CITY OF ALBUQUERQUE

September 14, 2017

**Re: Del Norte Baptist Church
5800 Montgomery Blvd. NE
Grading & Drainage Plan Engineer's Stamp Dated 8/1/17
(G18D010)**

EROSION AND SEDIMENT CONTROL PLAN

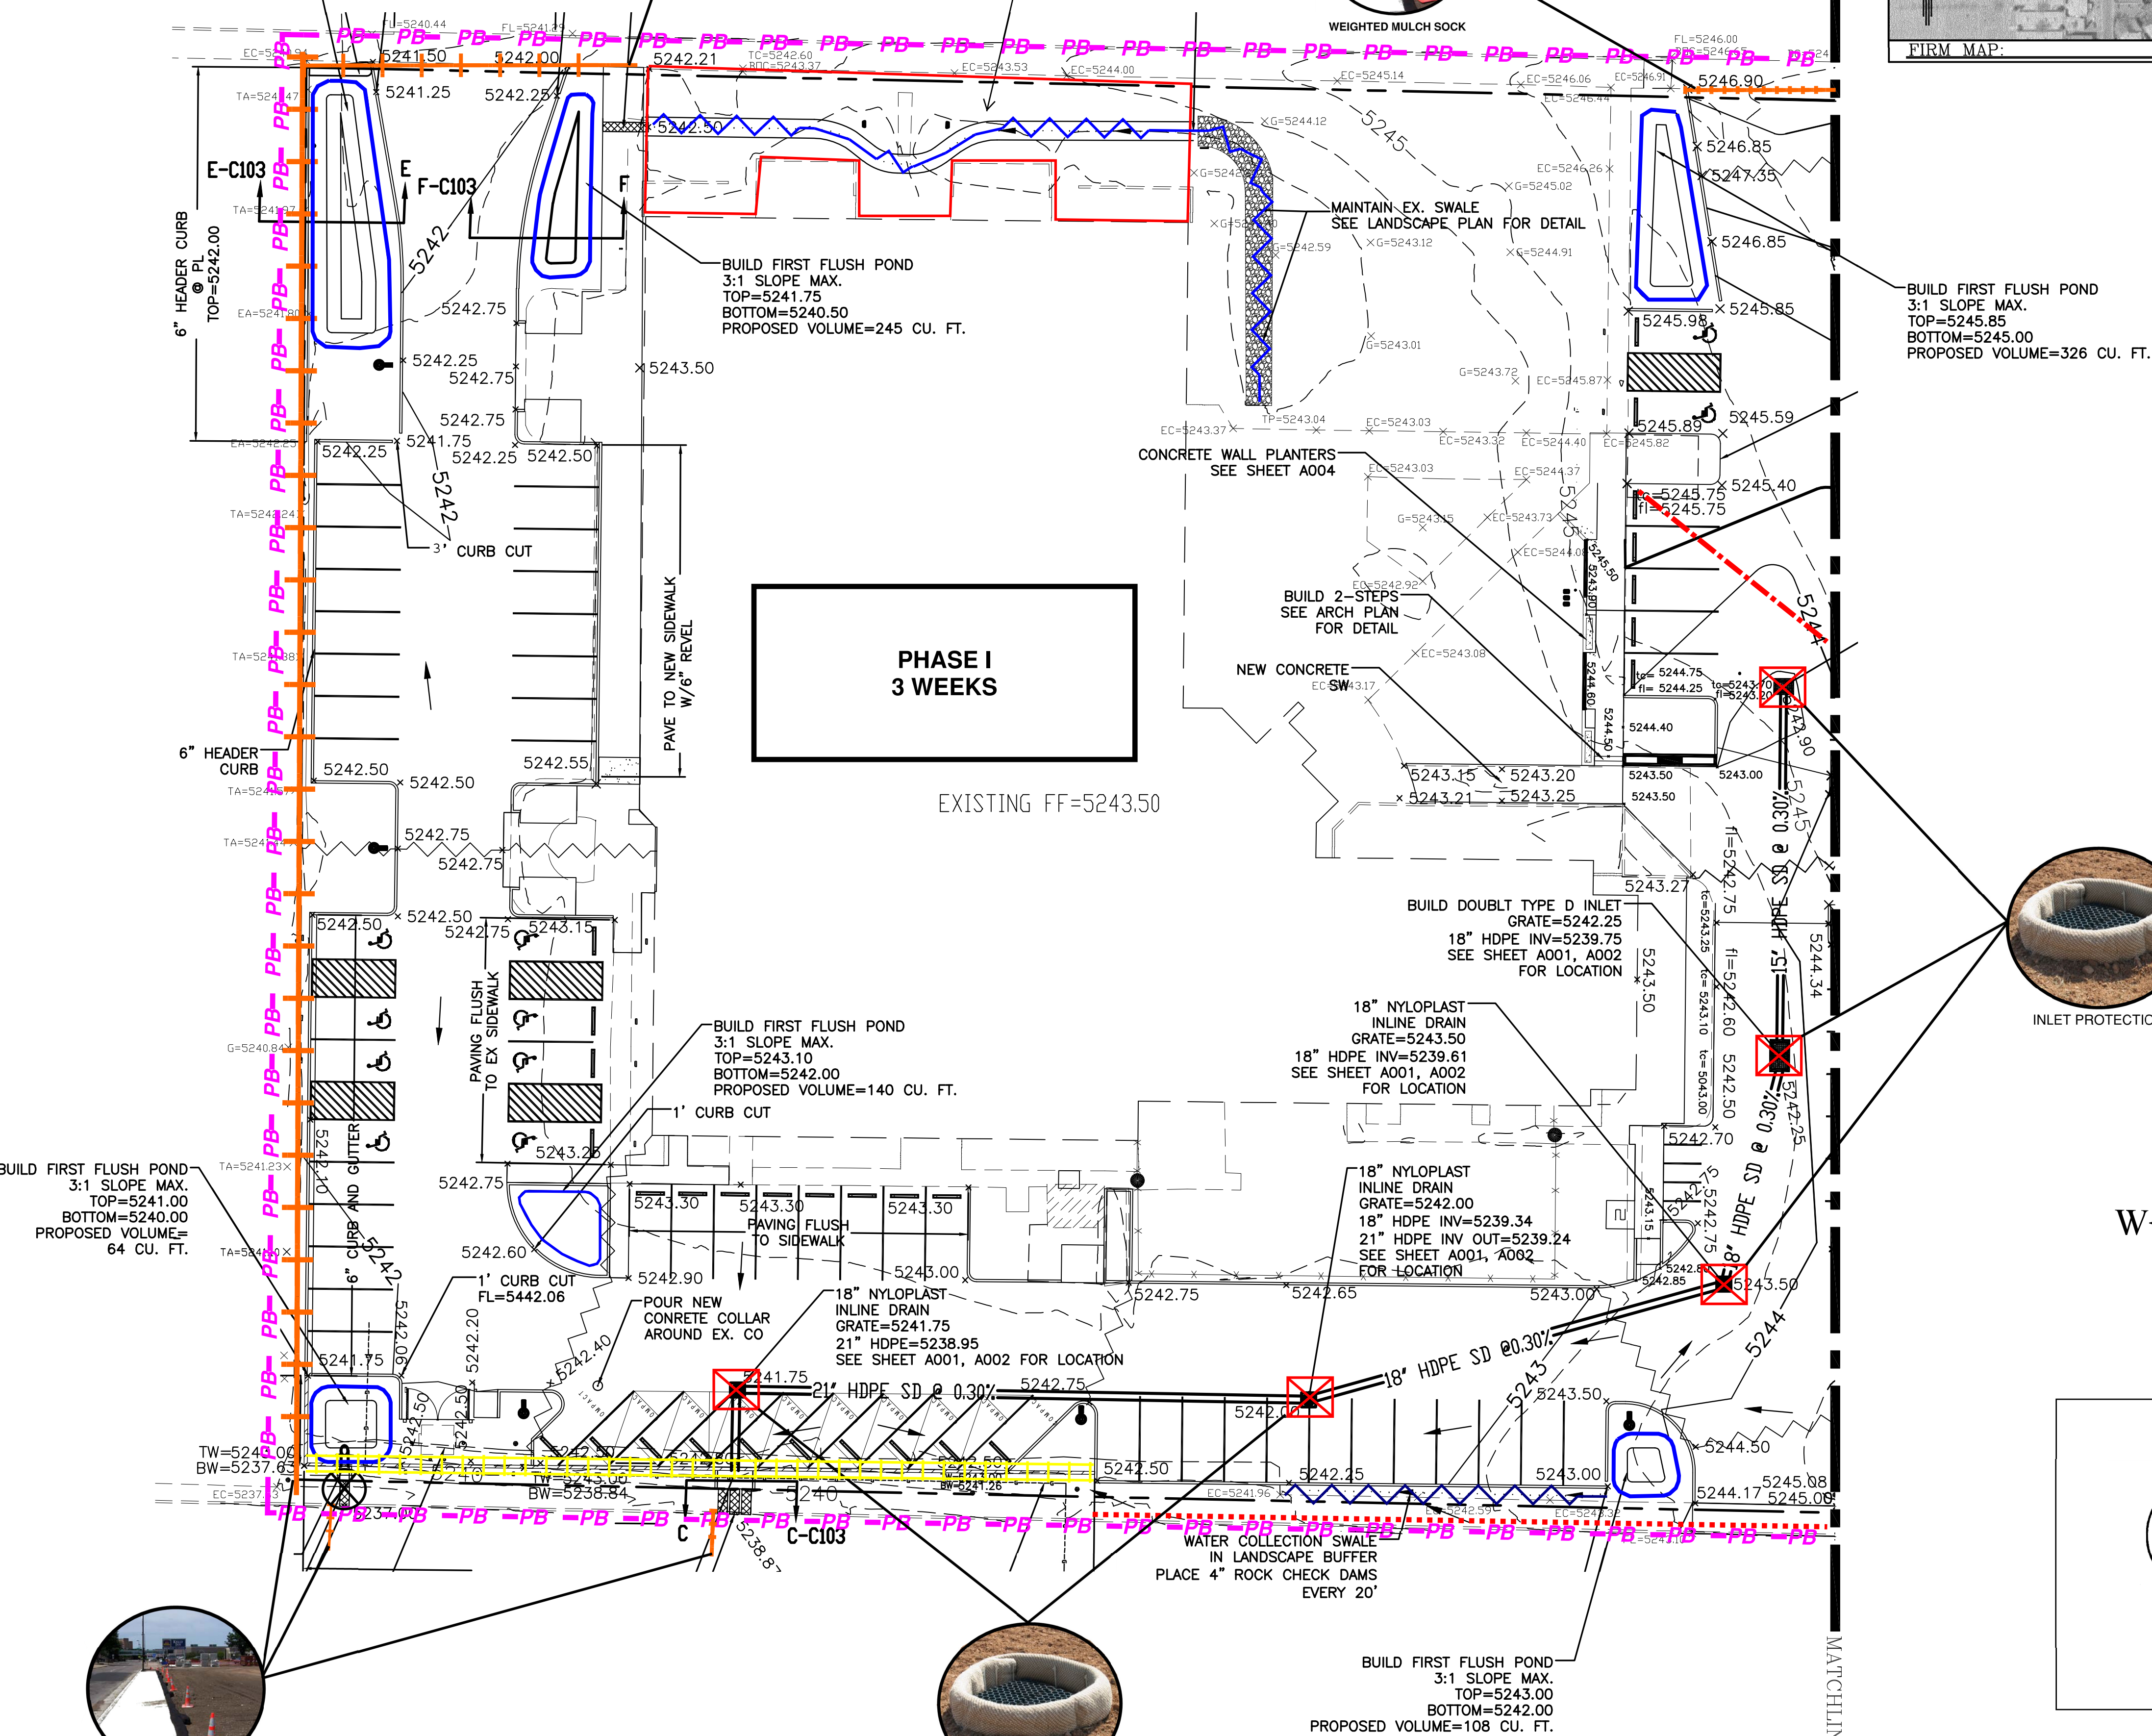
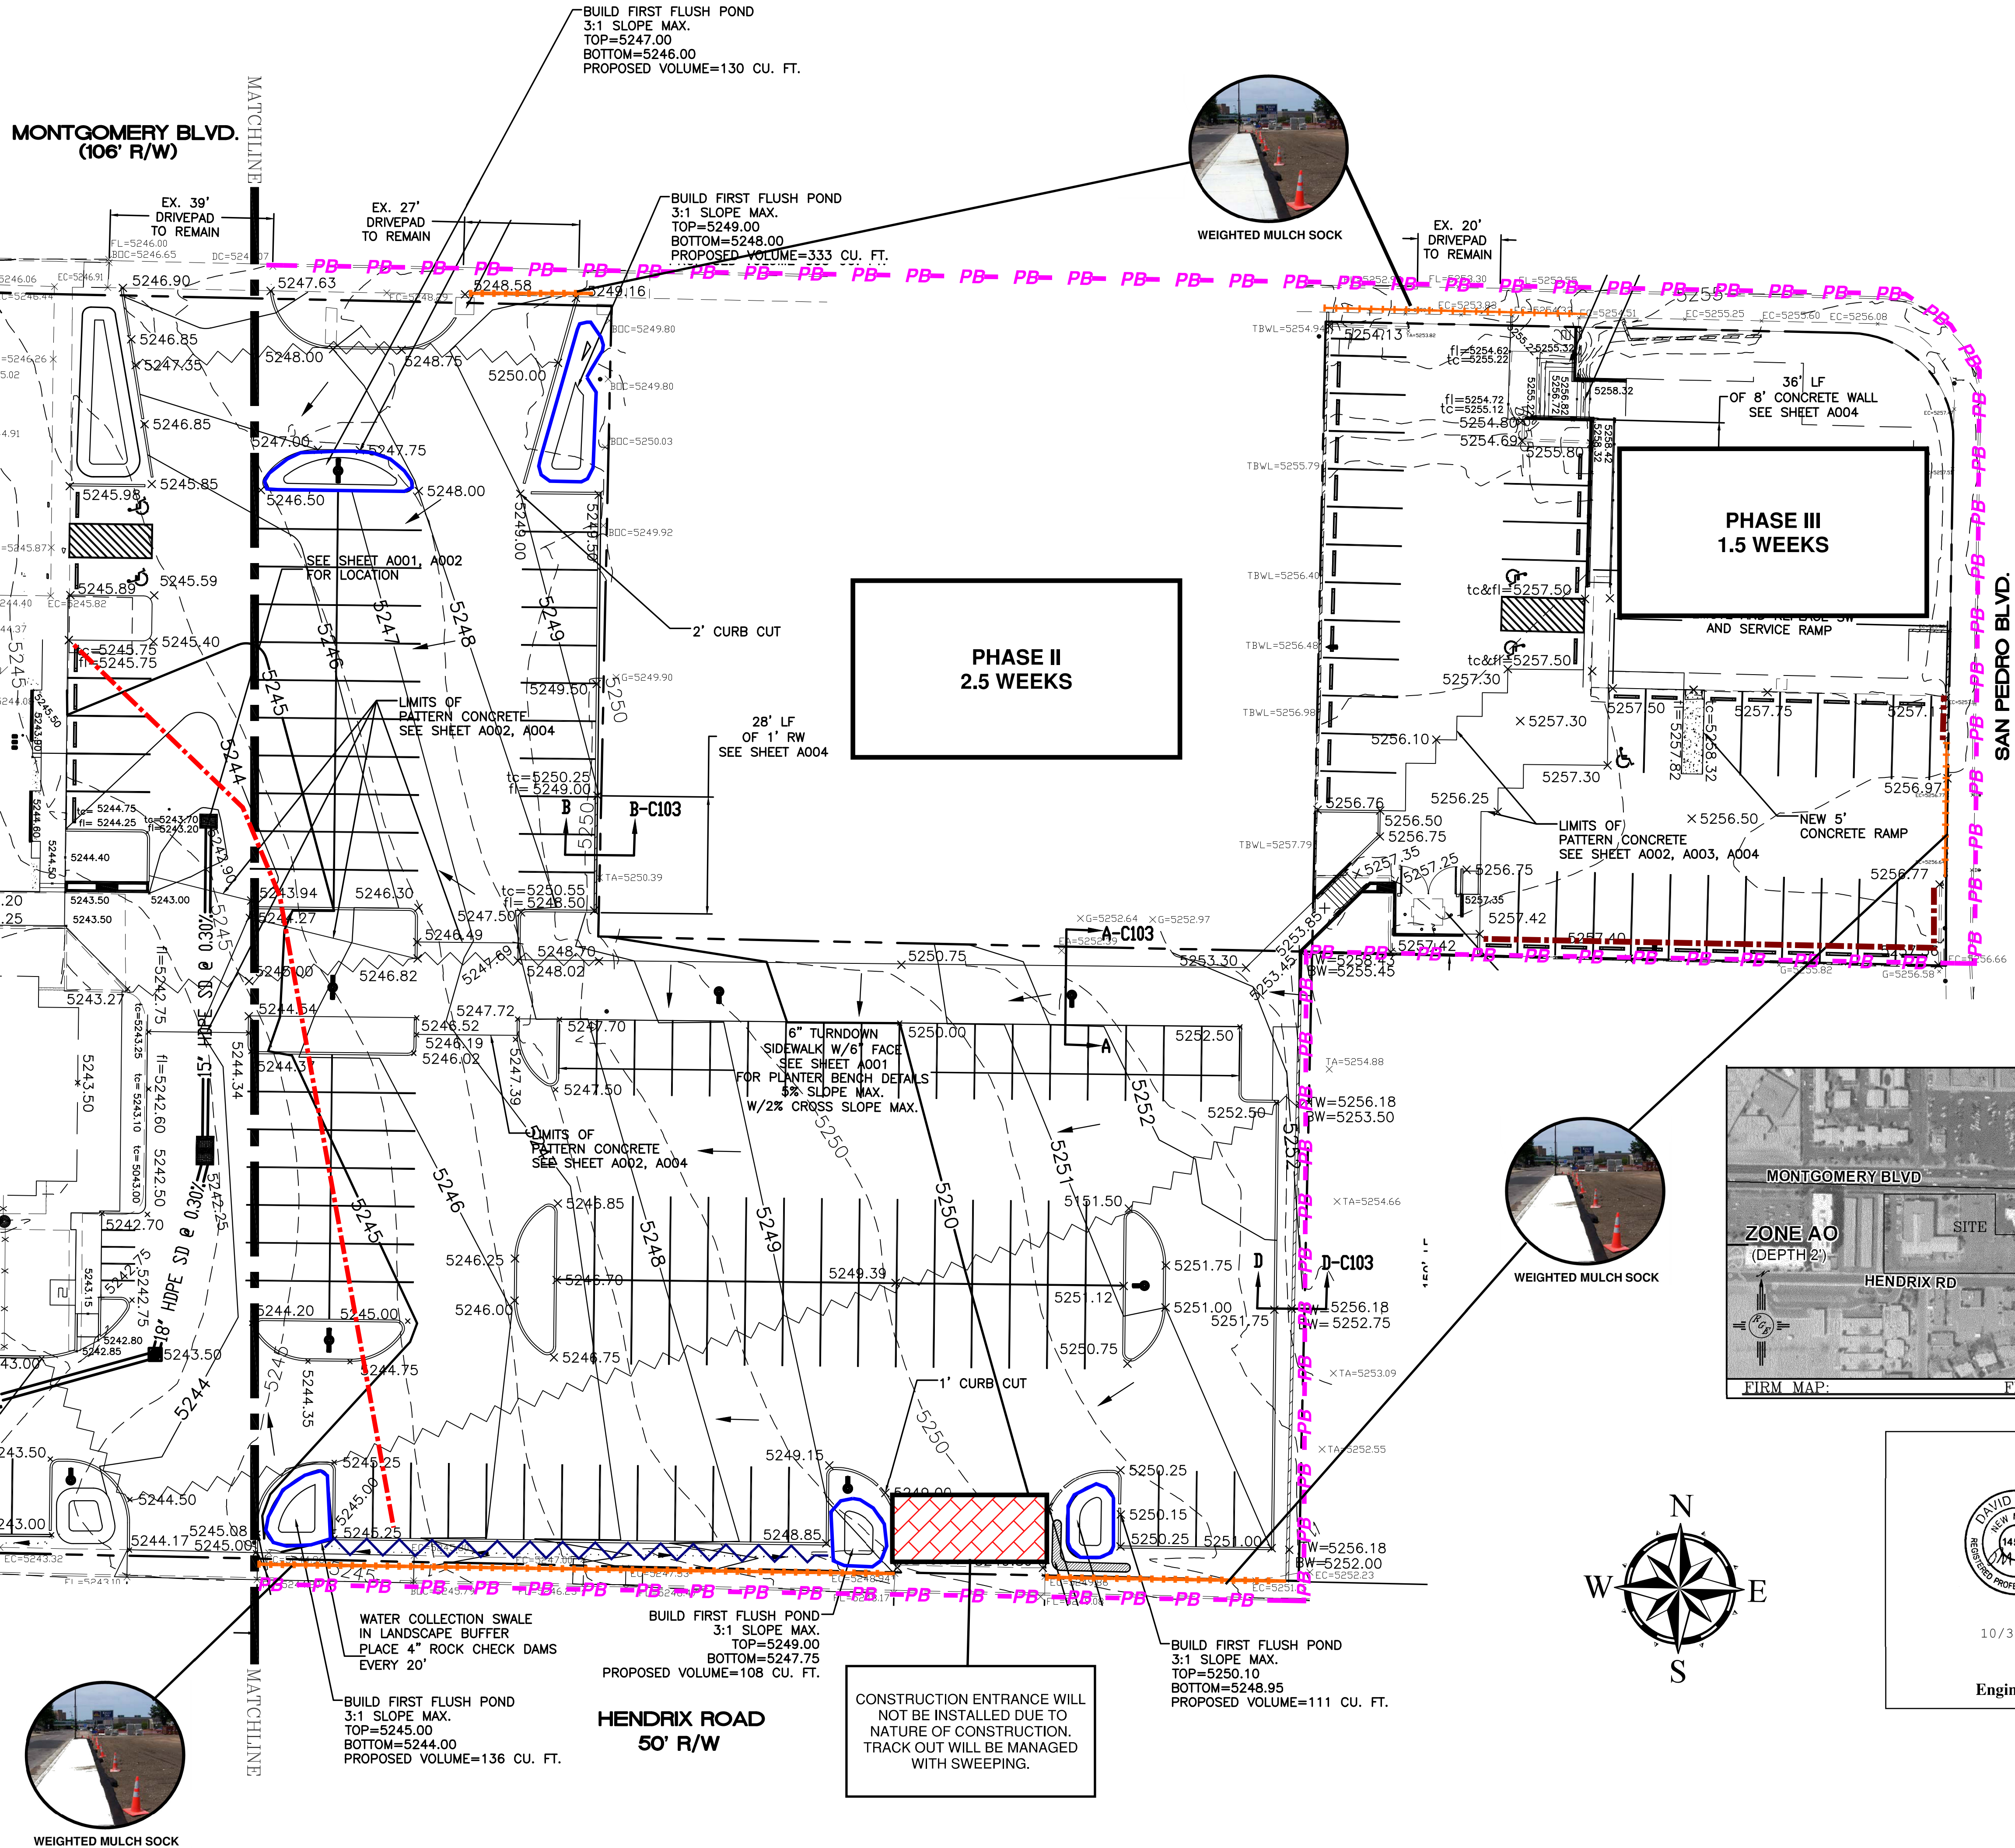
8. Provide first flush pond outfall details for the two new ponds on the west side of the site, flow capacity calculations, 100yr elevations, and make sure that the ponds will not overflow onto adjacent property to the west.
9. An ESC plan must be submitted to Stormwater Quality Control prior to Grading Plan approval. After the ESC plan is approved an ESC Permit must be obtained prior to beginning construction.

Project No. 21635  
Drawn By: WCM  
Checked By: ds  
Date: 05.26.2017  
Sheet No. **C102**

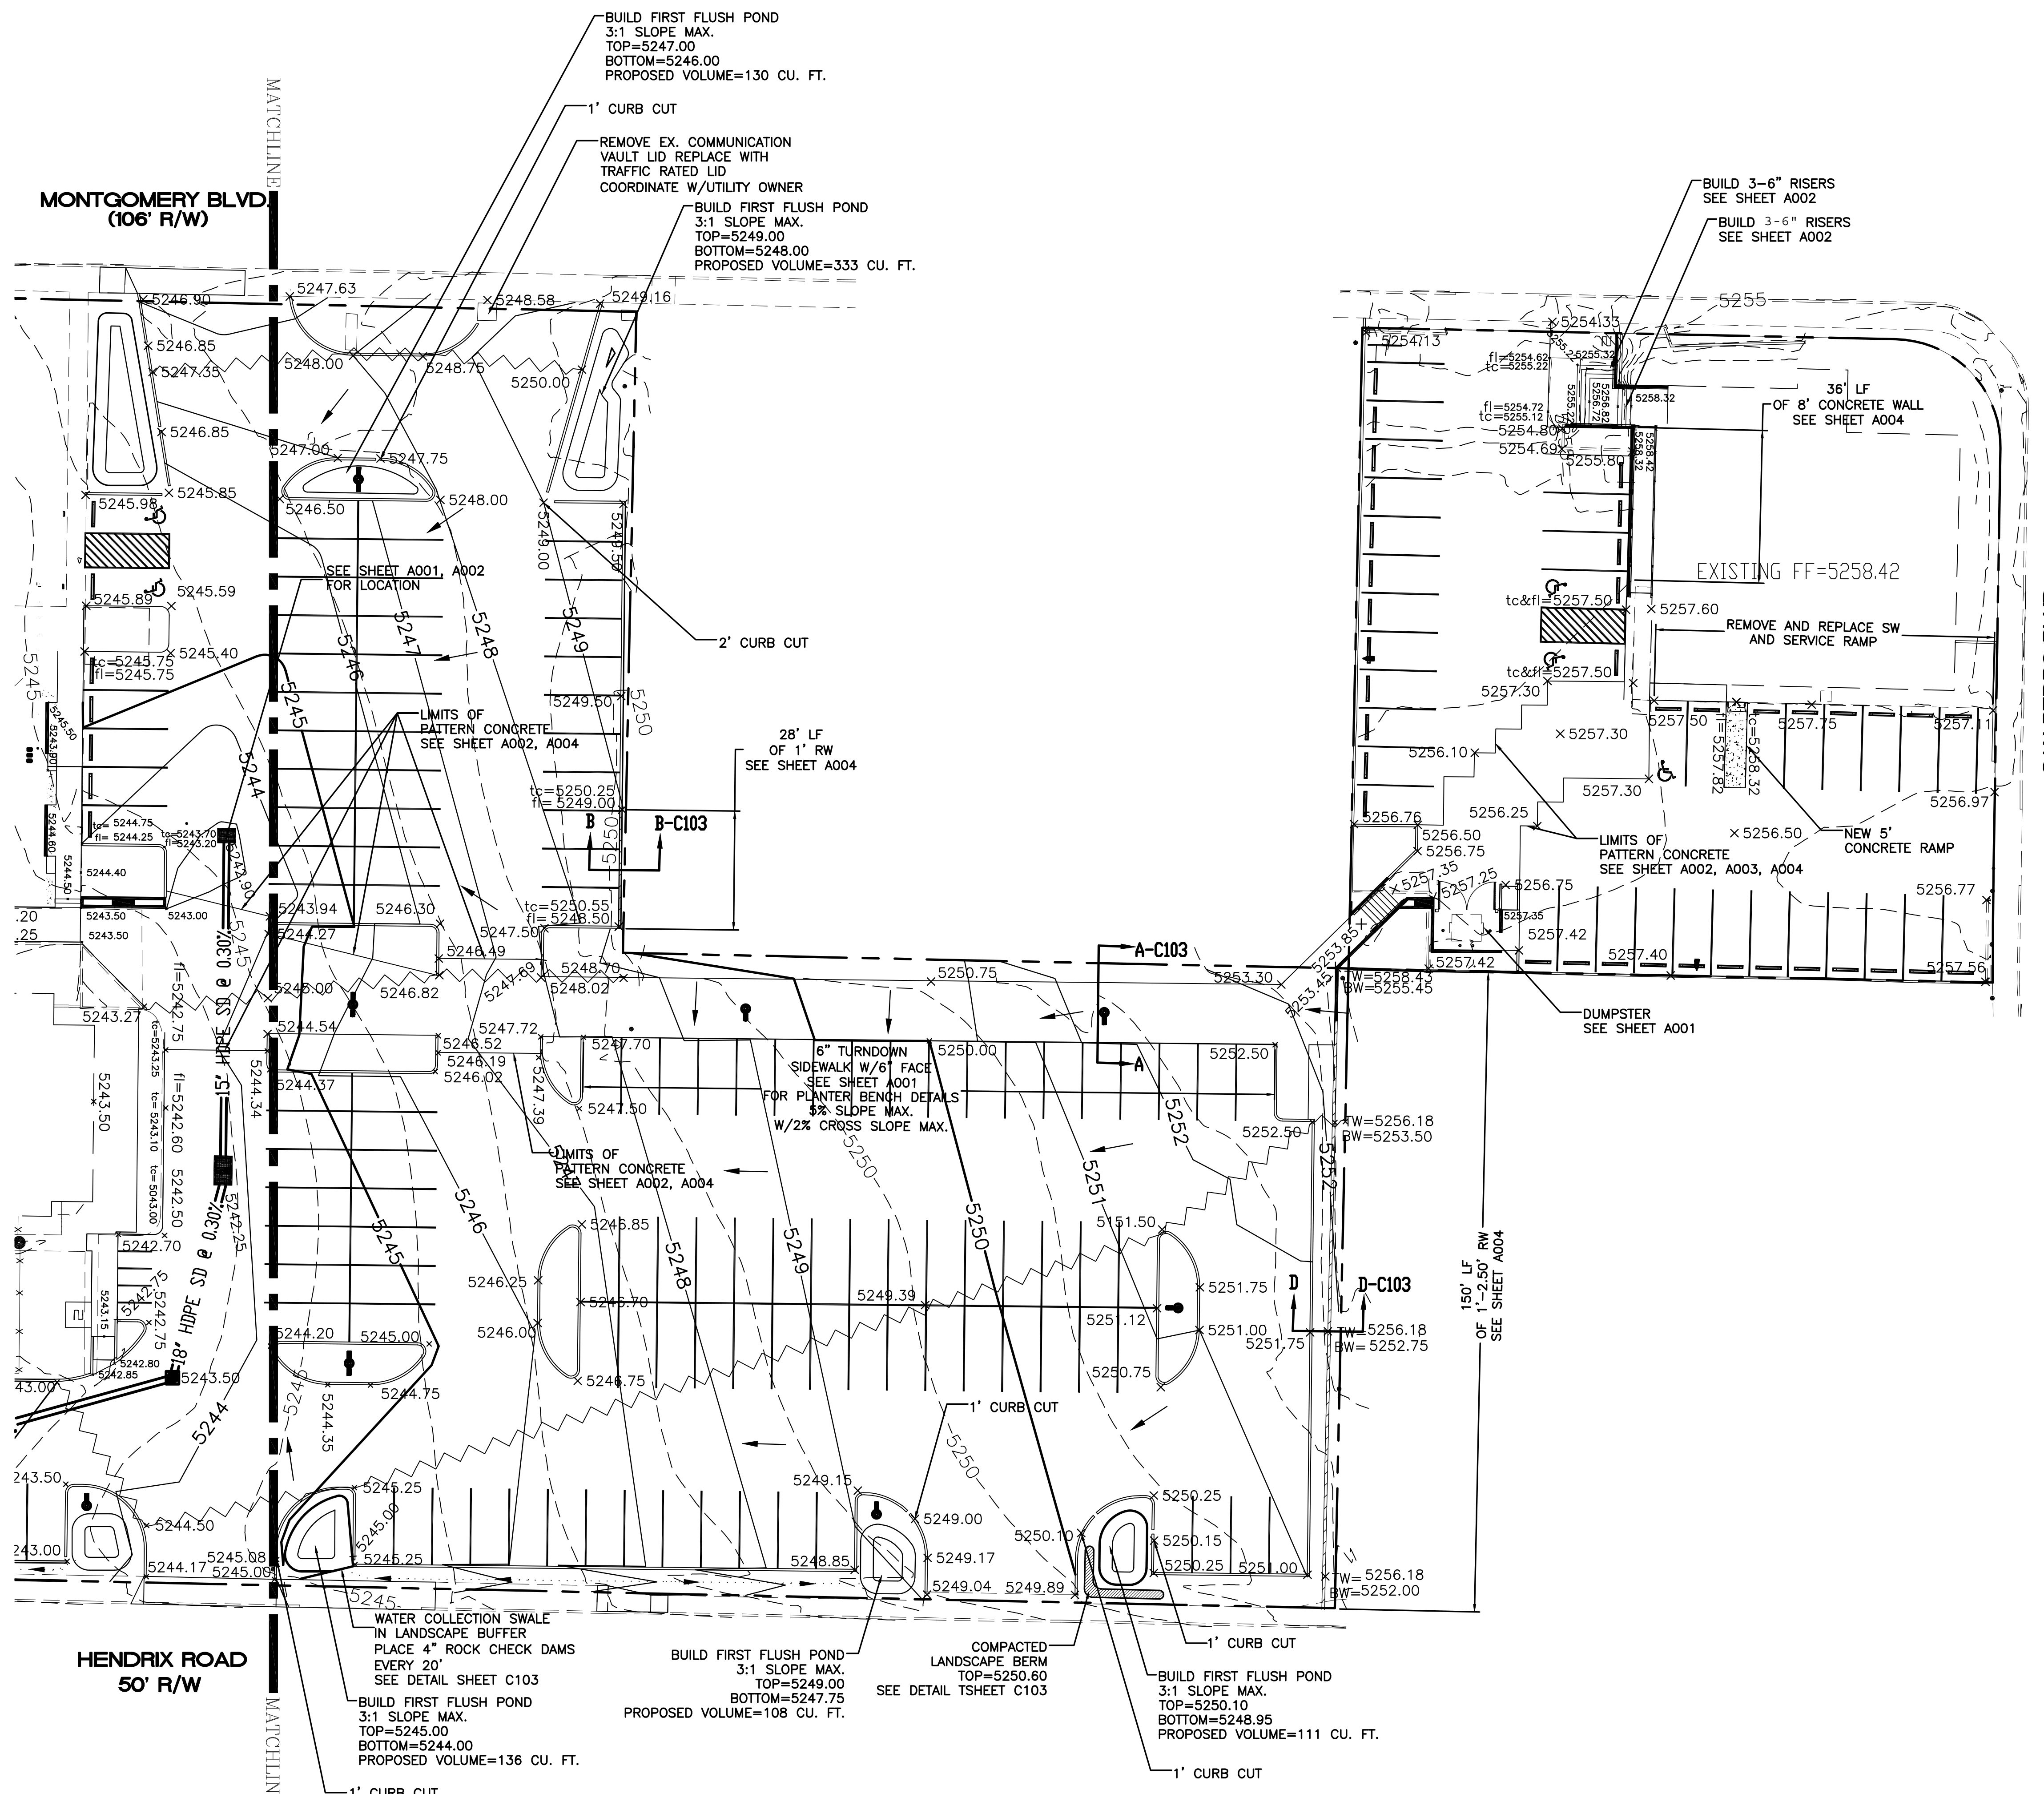
1. Add curb and gutter on Hendrix Rd where the driveway is being replaced with sidewalk.
2. Replace the header curb with curb and gutter along the south 1/3 of the west side of the site where drainage is diverted by the curb and

3. Add a header curb along the north 1/3 of the west property line to prevent drainage from spilling from the first flush pond into the neighboring property to the west.
